**Consultation Response from KC,
Trees**

2024/92140 16, Town Gate, Upperthong, Holmfirth, HD9 3UX

Erection of detached garage (within a Conservation Area)

Date Responded: 24/10/2024

Proposed Site Plan - 1:100

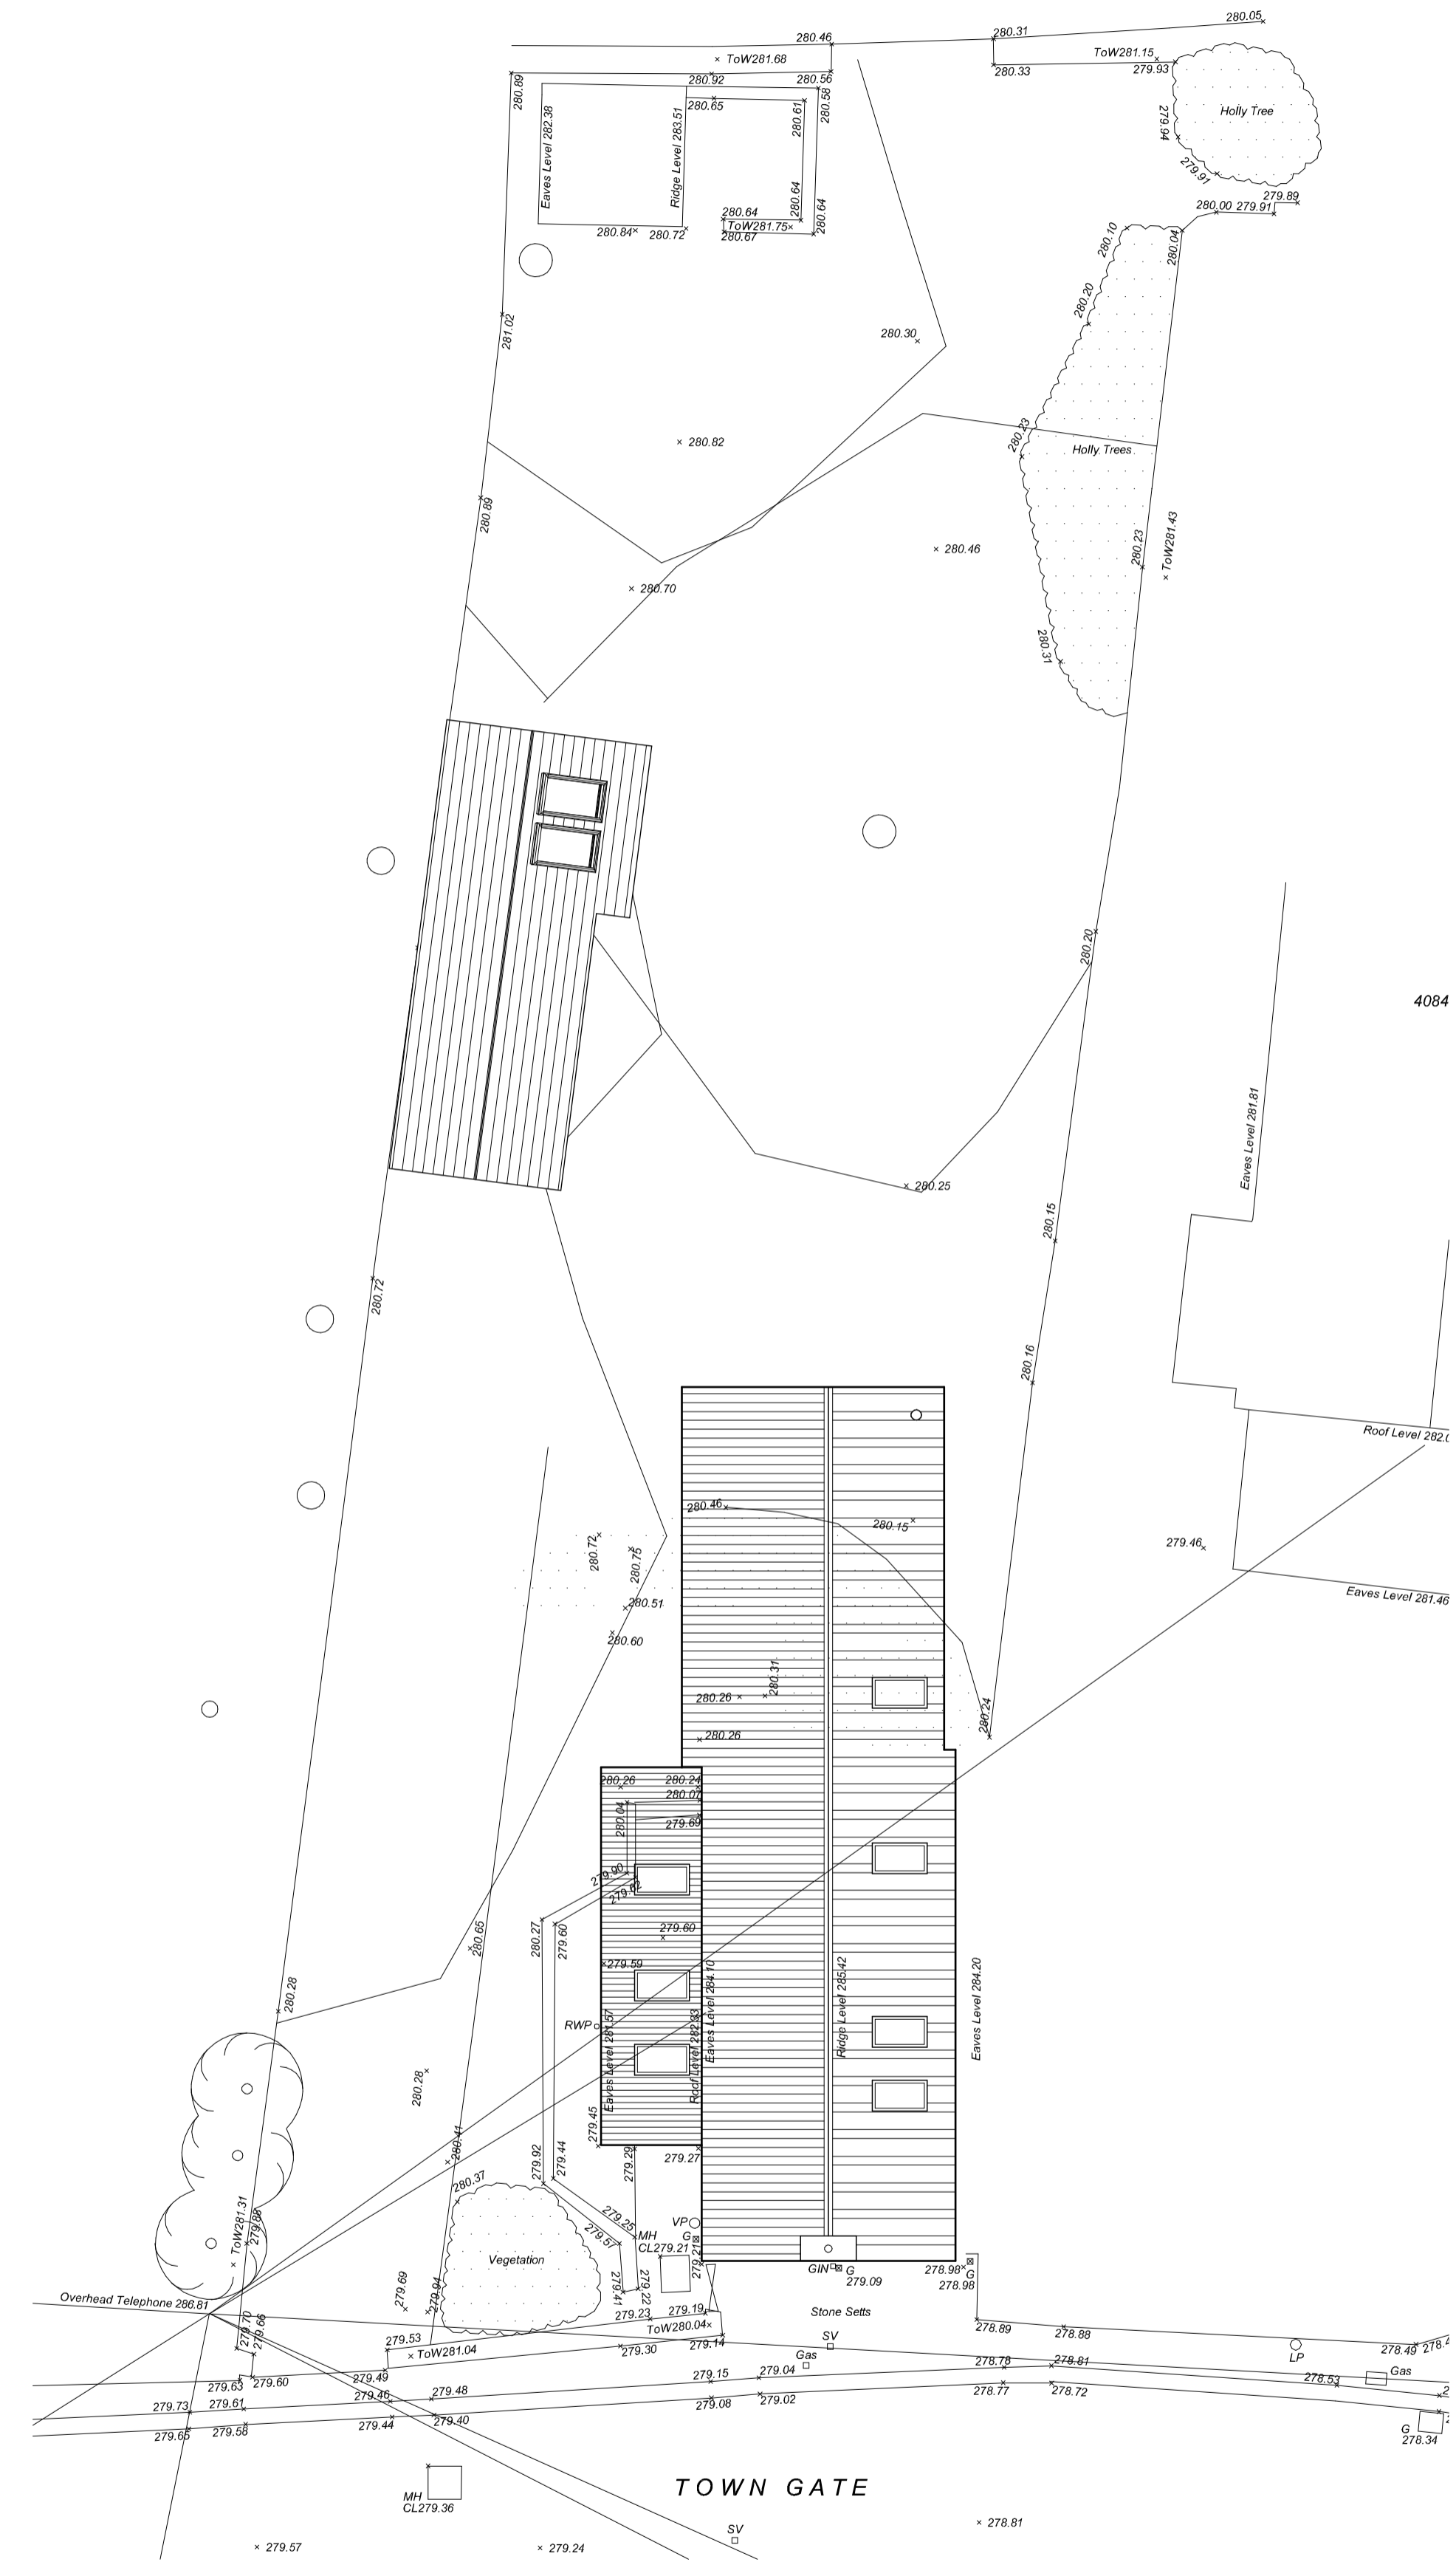
After receiving the tree information requested there is sufficient detail to show the impact on the trees. The building proposed is within the RPA of T2 which whilst isn't ideal may be achievable without any impact to the trees rooting system. As mentioned in the AIA there presence of roots in the proposed footing area is likely to be minimal but this can't be confirmed until ground is broken. The AIA suggests trial pits to be dug using hand dig techniques and I would agree providing the trial excavations is overseen by the project arboriculturalist.

- Any excavation within the RPA of T2 is performed using hand tools rather than machinery and that the process is overseen by the project arboriculturalist.
- That if significant roots are observed then a pile and beam foundation will be utilised to bridge any roots offering them future space to grow.
